Meridian Ranch Sketch Plan  
2017 Amendment  
Traffic Impact Analysis  
(LSC #174350)  
July 7, 2017

RE: Meridian Ranch Sketch Plan  
2017 Amendment  
El Paso County, CO  
Traffic Impact Analysis  
LSC #174350

**MERIDIAN RANCH
SKETCH PLAN**

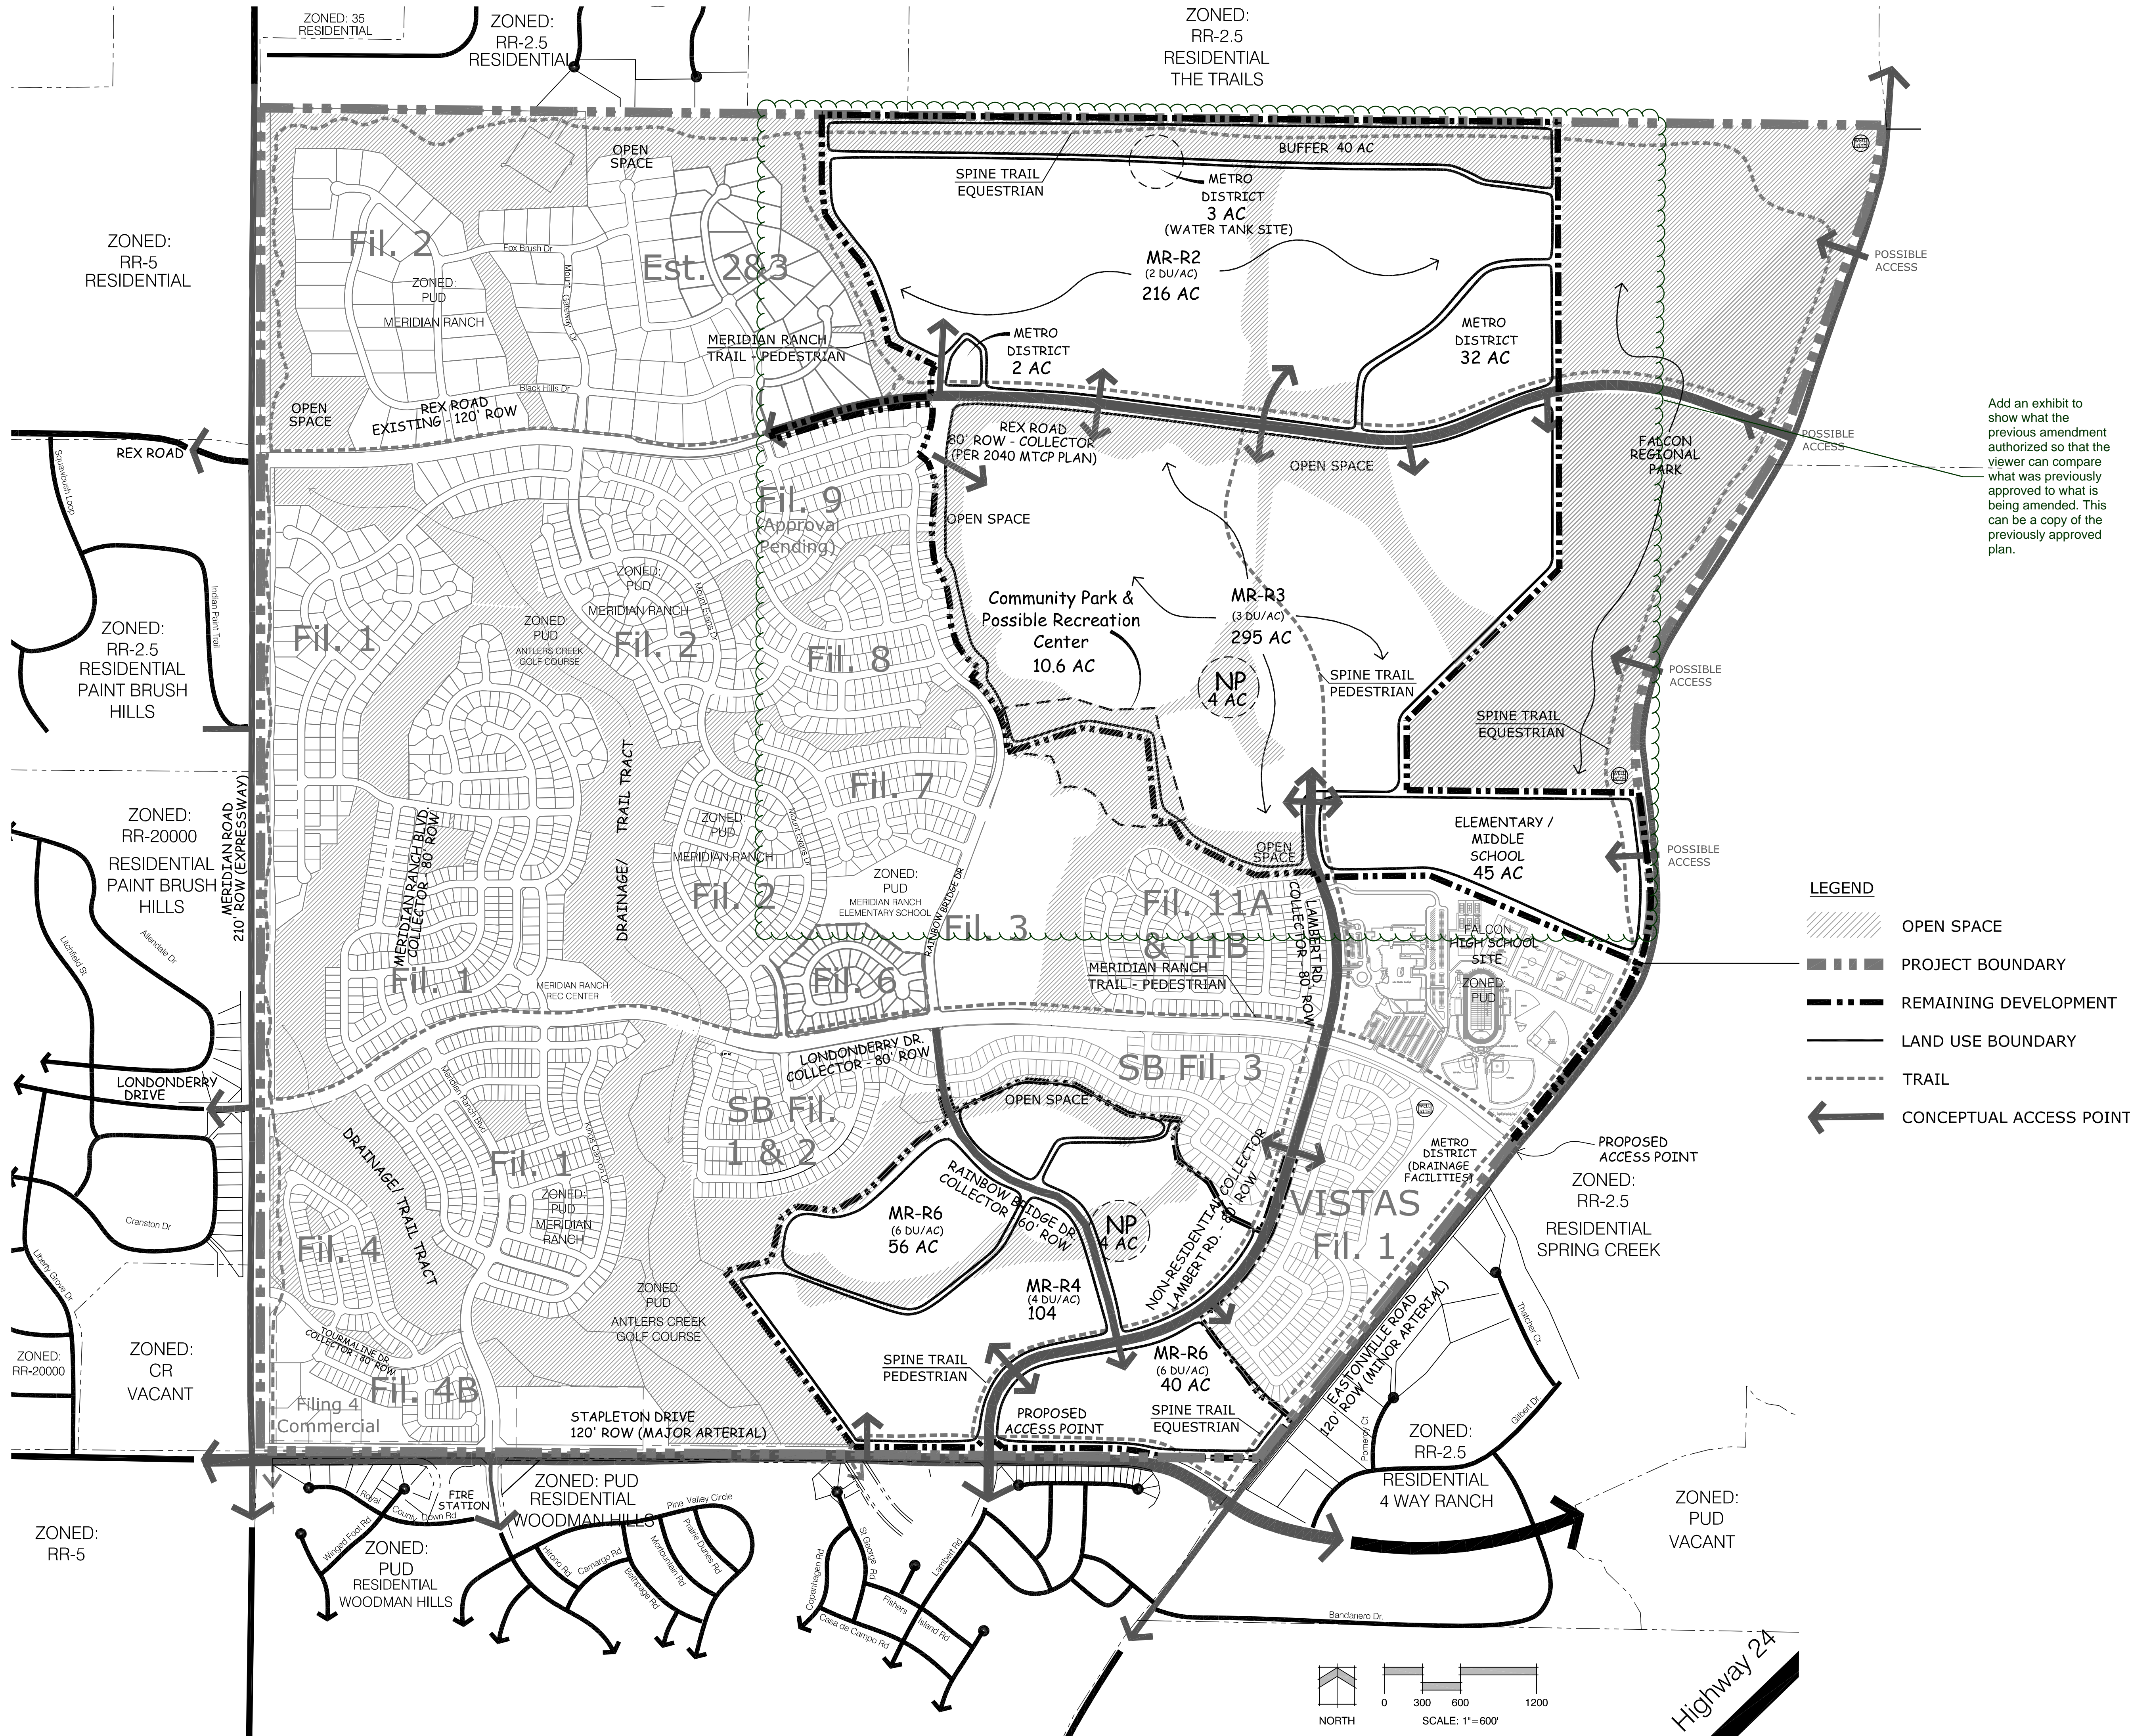
The totals do not match the sketch plan amendment. Update this or the sketch plan so the numbers match.
